From: Peter pritchard <[REDACTED]>
Sent: 20 April 2021 14:29
To: Planning.Responses; Nicola Moore
Subject: Re: Request for further information LU/114/21/CLP
Attachments: new floor plan.jpeg; north elevation new.jpeg

LU/114/21/CLP

Existing Roof Plan.

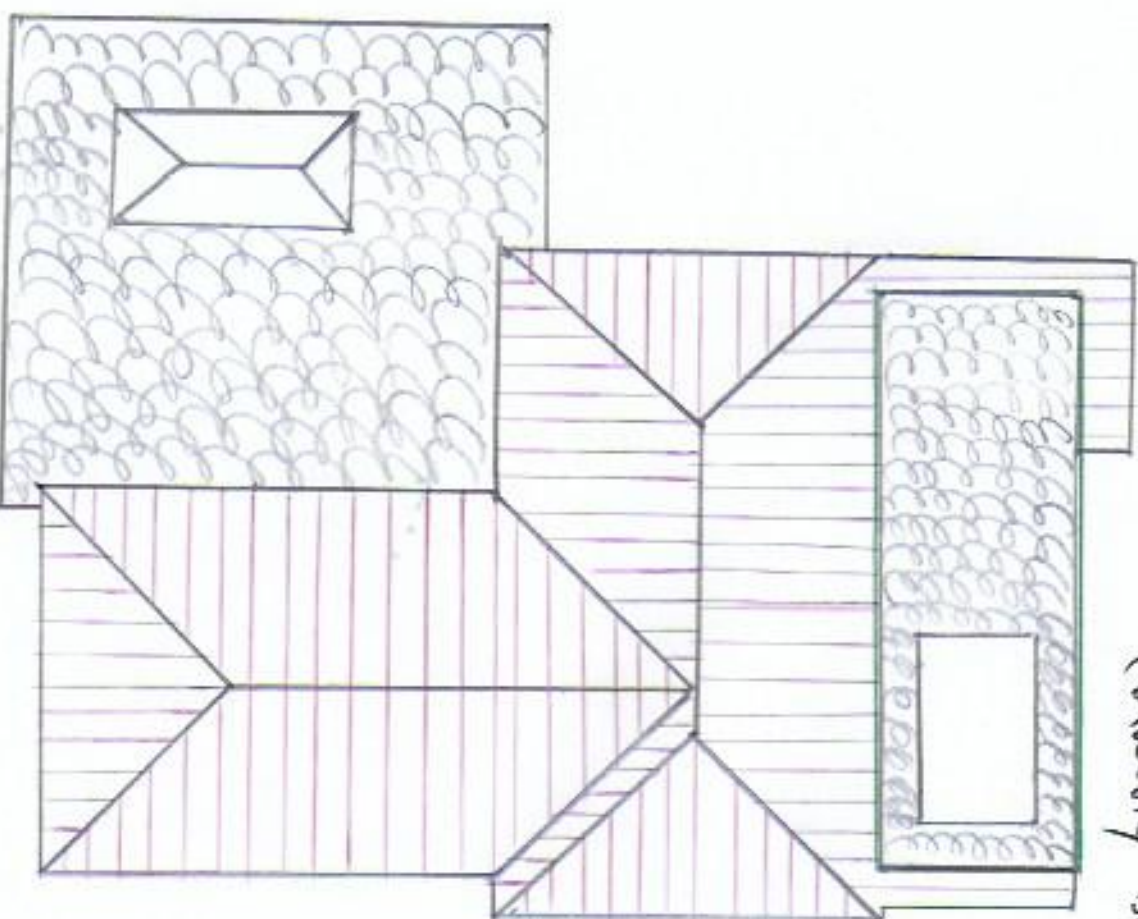
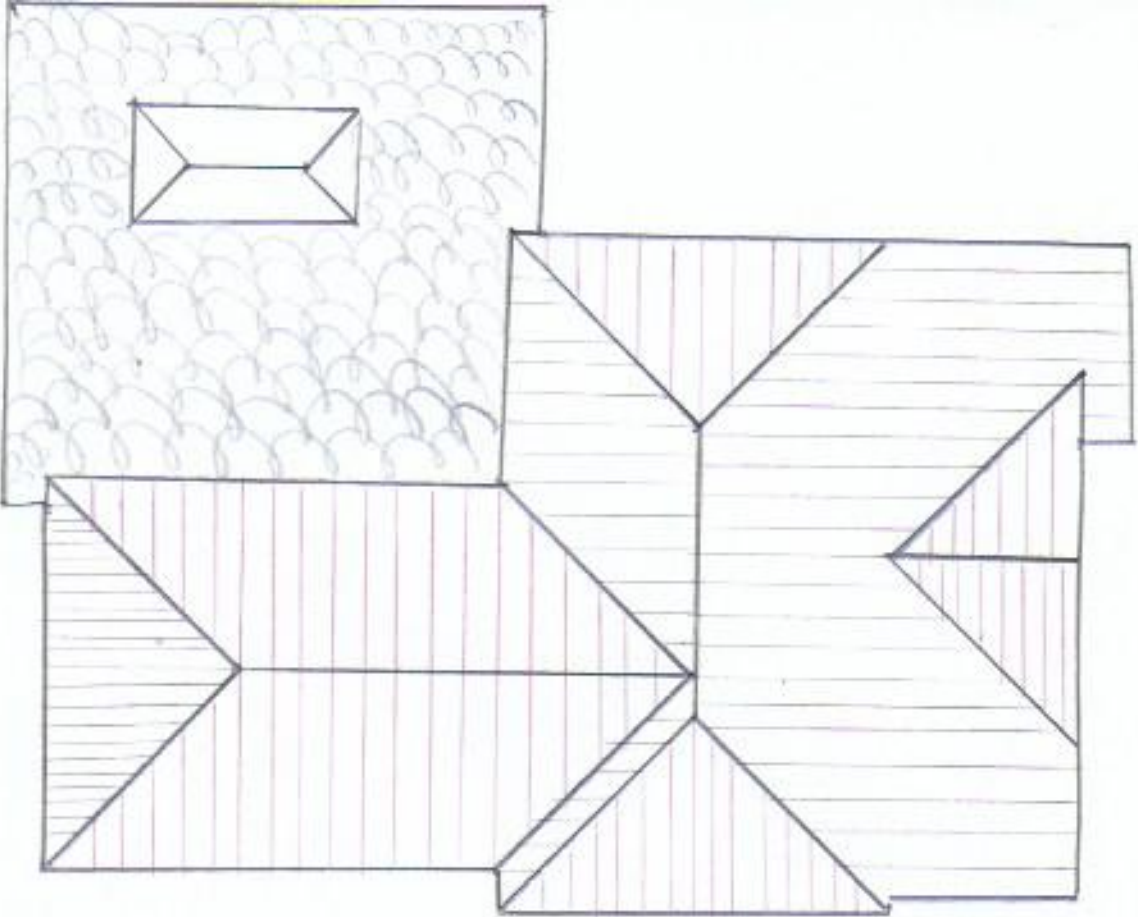
The existing roof plan shows the correct size of 7.6m with allowing overhang for the dormer flat roof.

Apple tree Cottage
Proposed Rear
Dormer

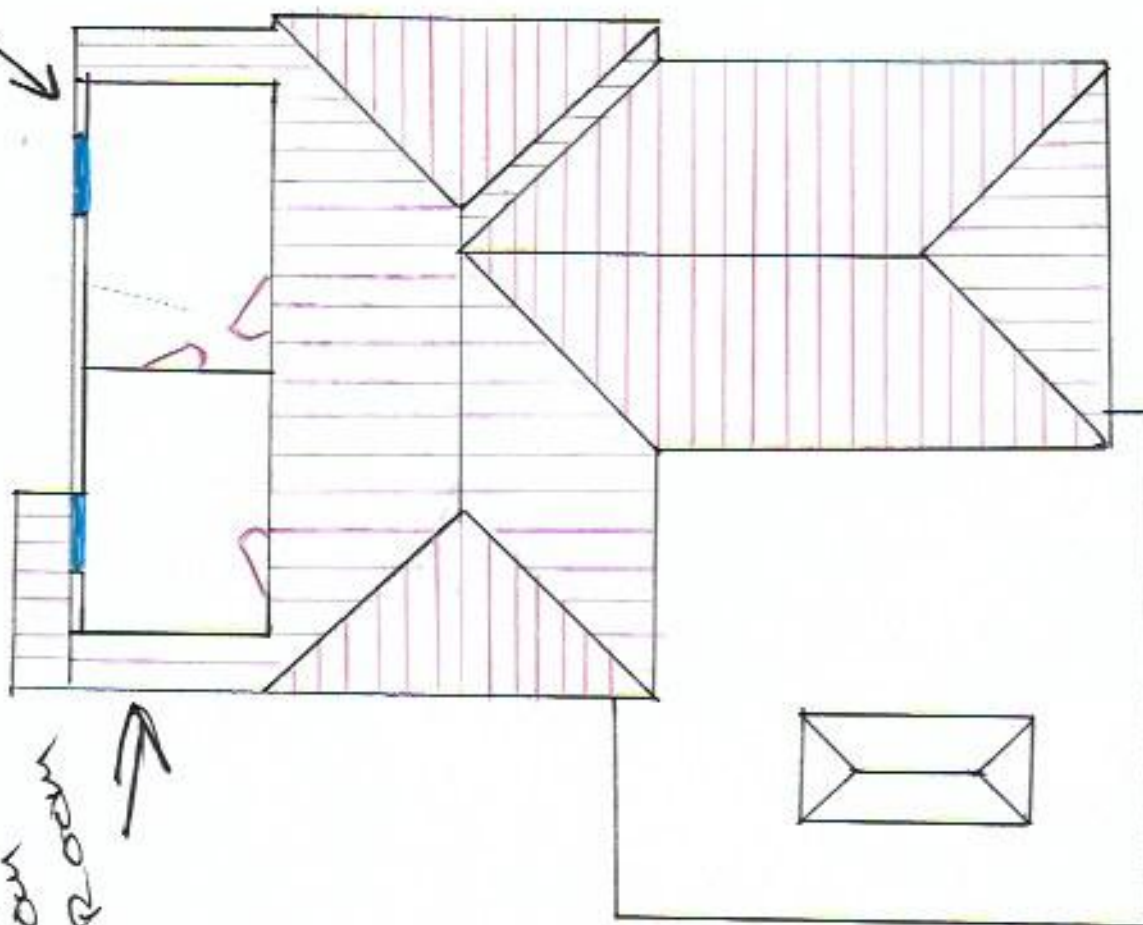
I have corrected the floor plan and North elevation plans to show the correct size of 7.3m for the external dimensions of the sides of the dormer.
